From: Clay Barnett
Sent: Tuesday, March 10, 2009 3:45 PM
To: Carmen Moran
Subject: Meridian Square Replat

I have only one comment on the Meridian Square Replat. It is as follows:

51 LOTS ~ 4.019 ACRES
FINAL PLAT
MERIDIAN SQUARE
A REPLAT OF
QUORUM EAST ADDITION
TOWN OF ADDISON
G.W. FISHER SURVEY ~ ABSTRACT NO. 482
DALLAS COUNTY, TEXAS
OCTOBER 2008 SCALE: 1"=30'
OWNERS
ADDISON URBAN DEVELOPMENT PARTNERS, LLC
500 W. LOOKOUT DRIVE
972-248-2147 RICHARDSON, TEXAS 75080
ENGINEER

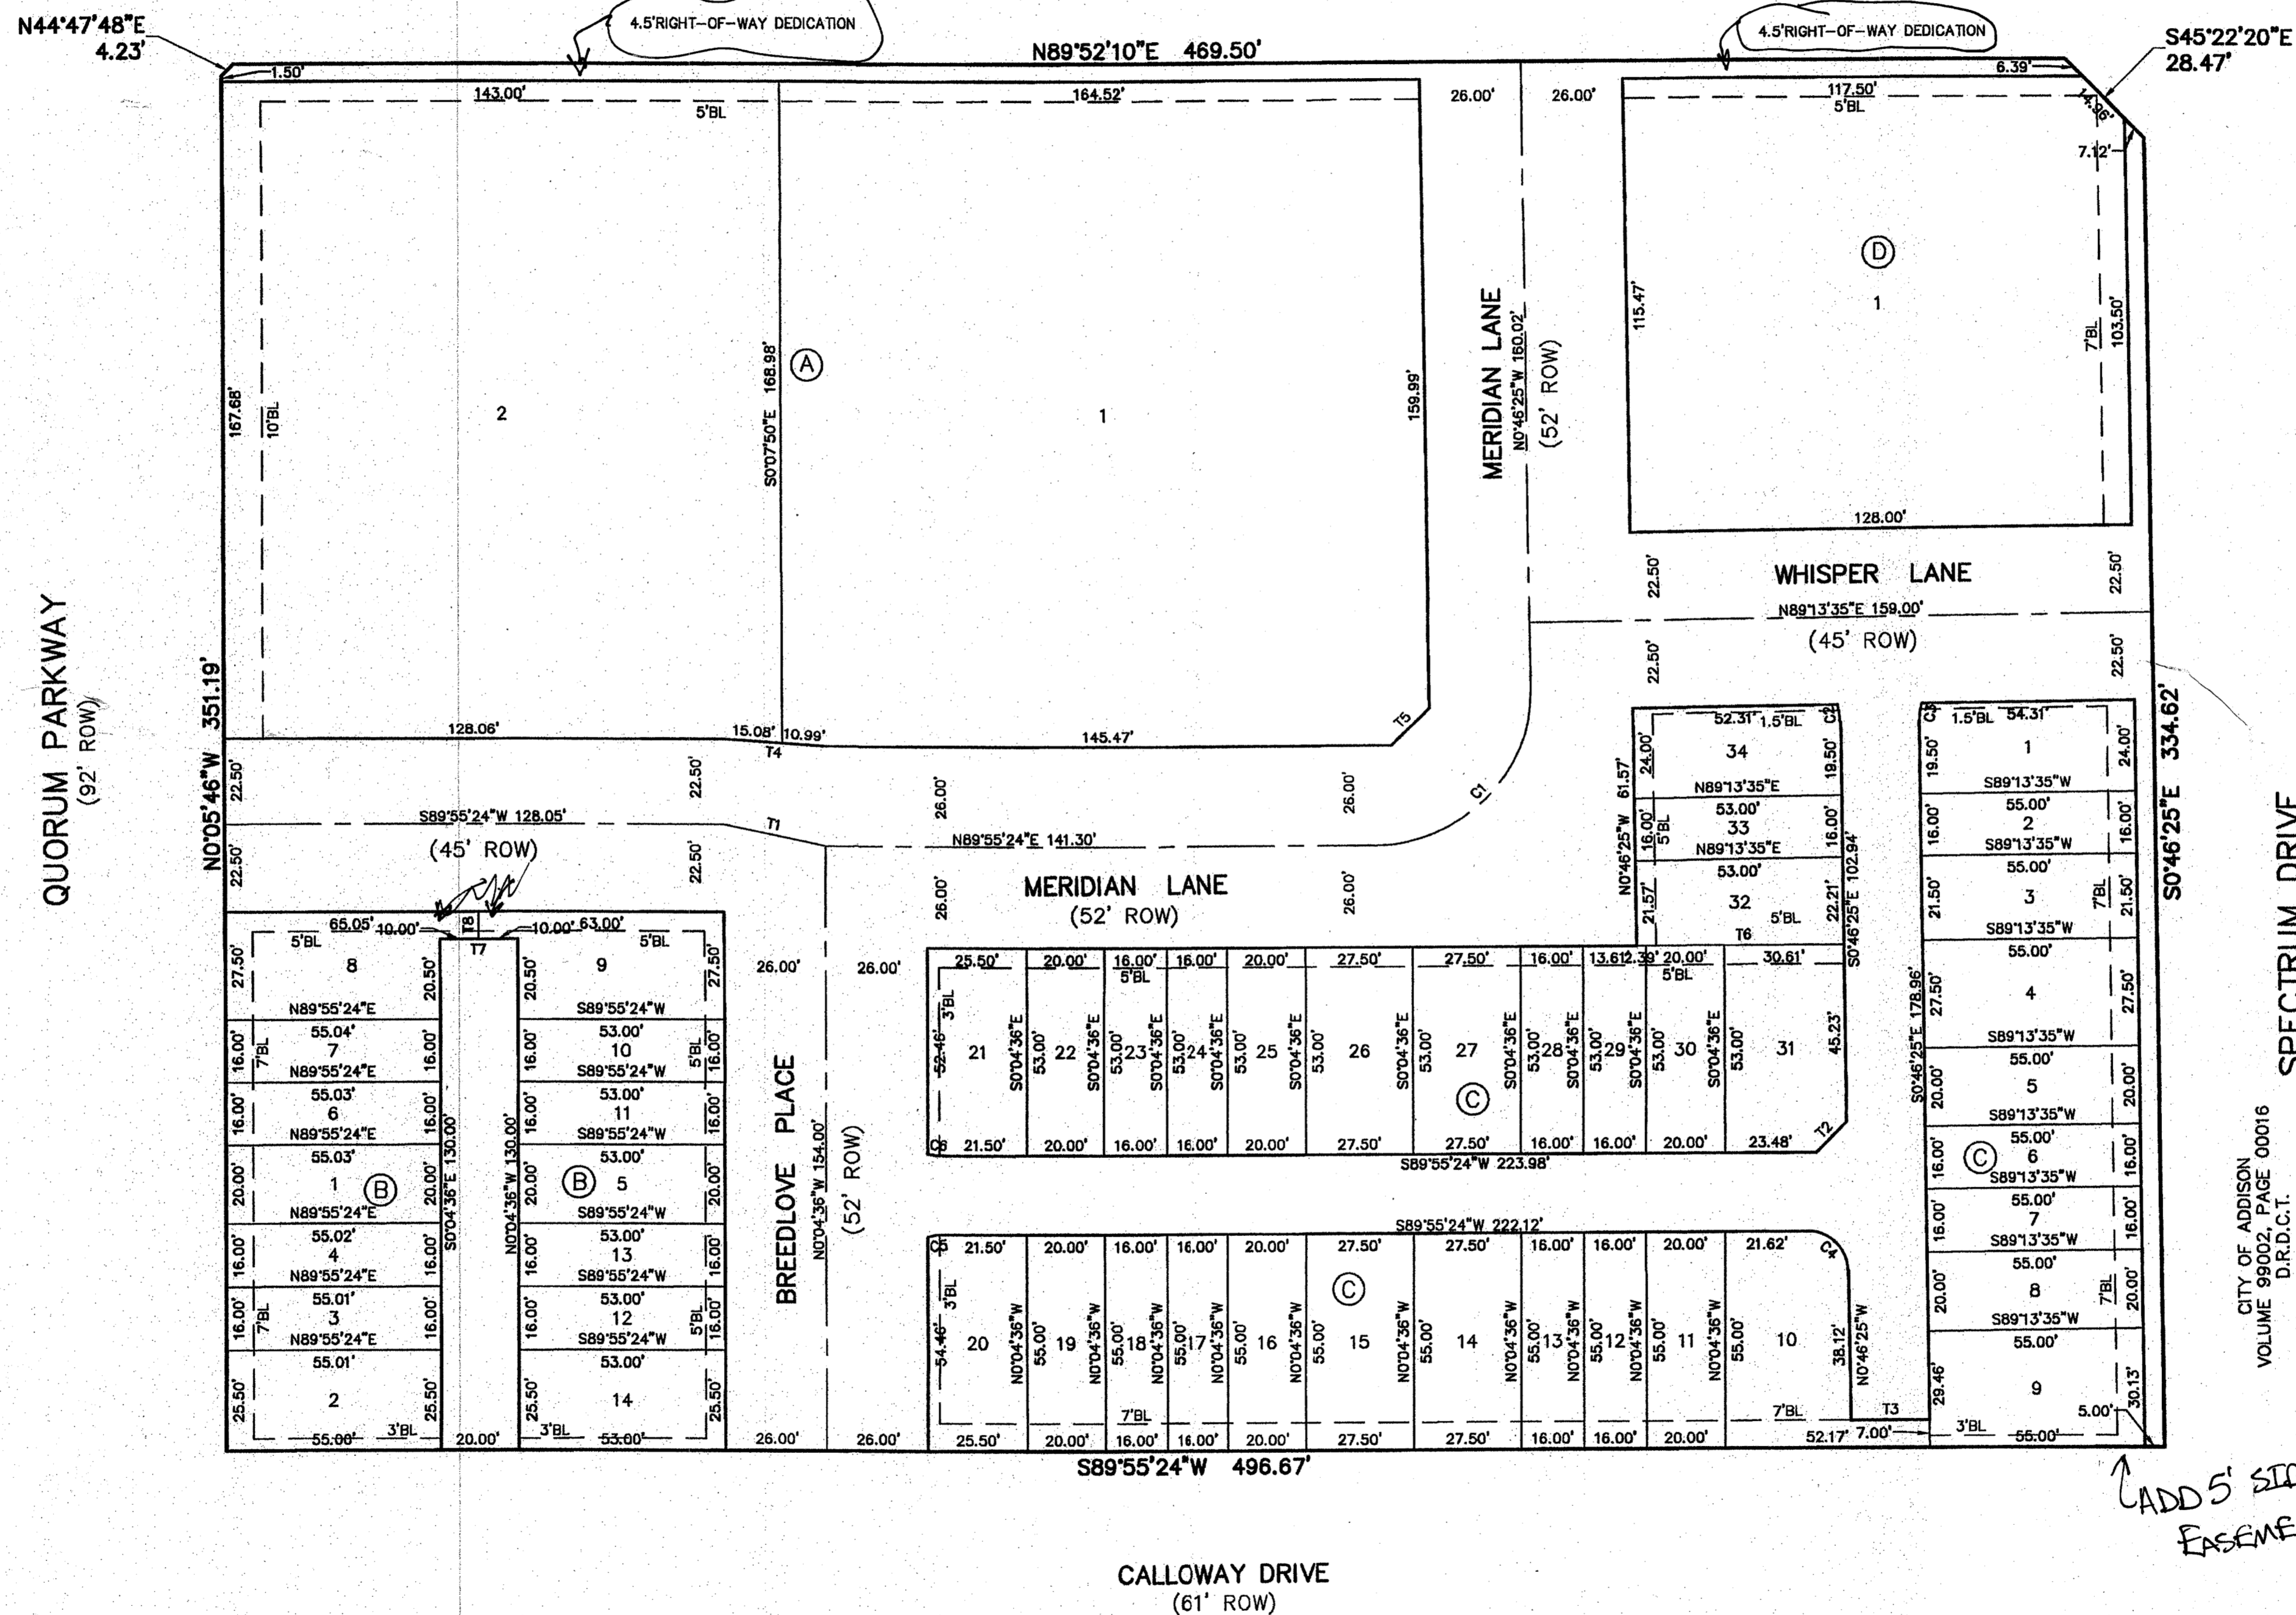
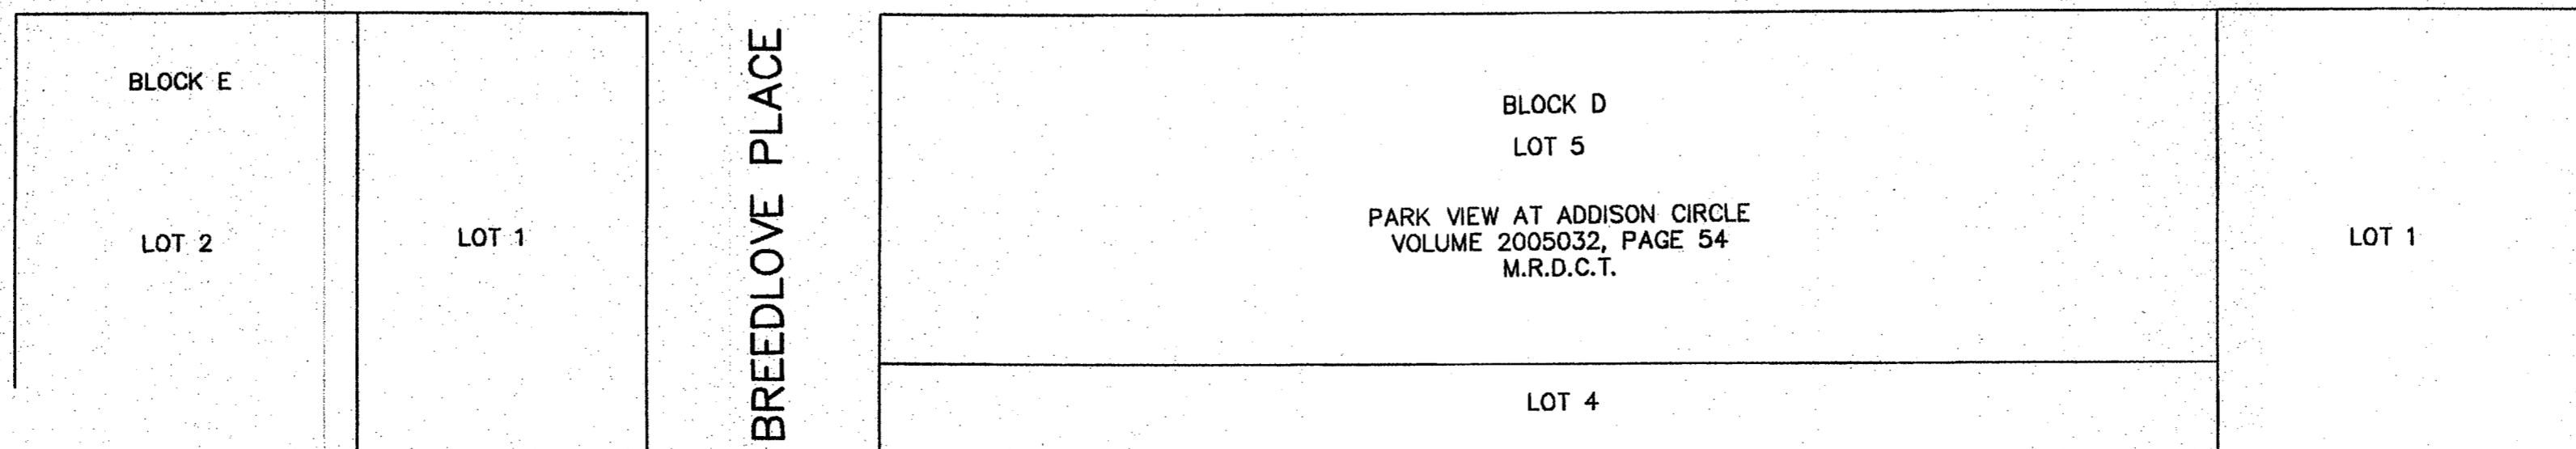
1. The centerline location and dimension shown for Quorum Drive appear to be incorrect. Please address.
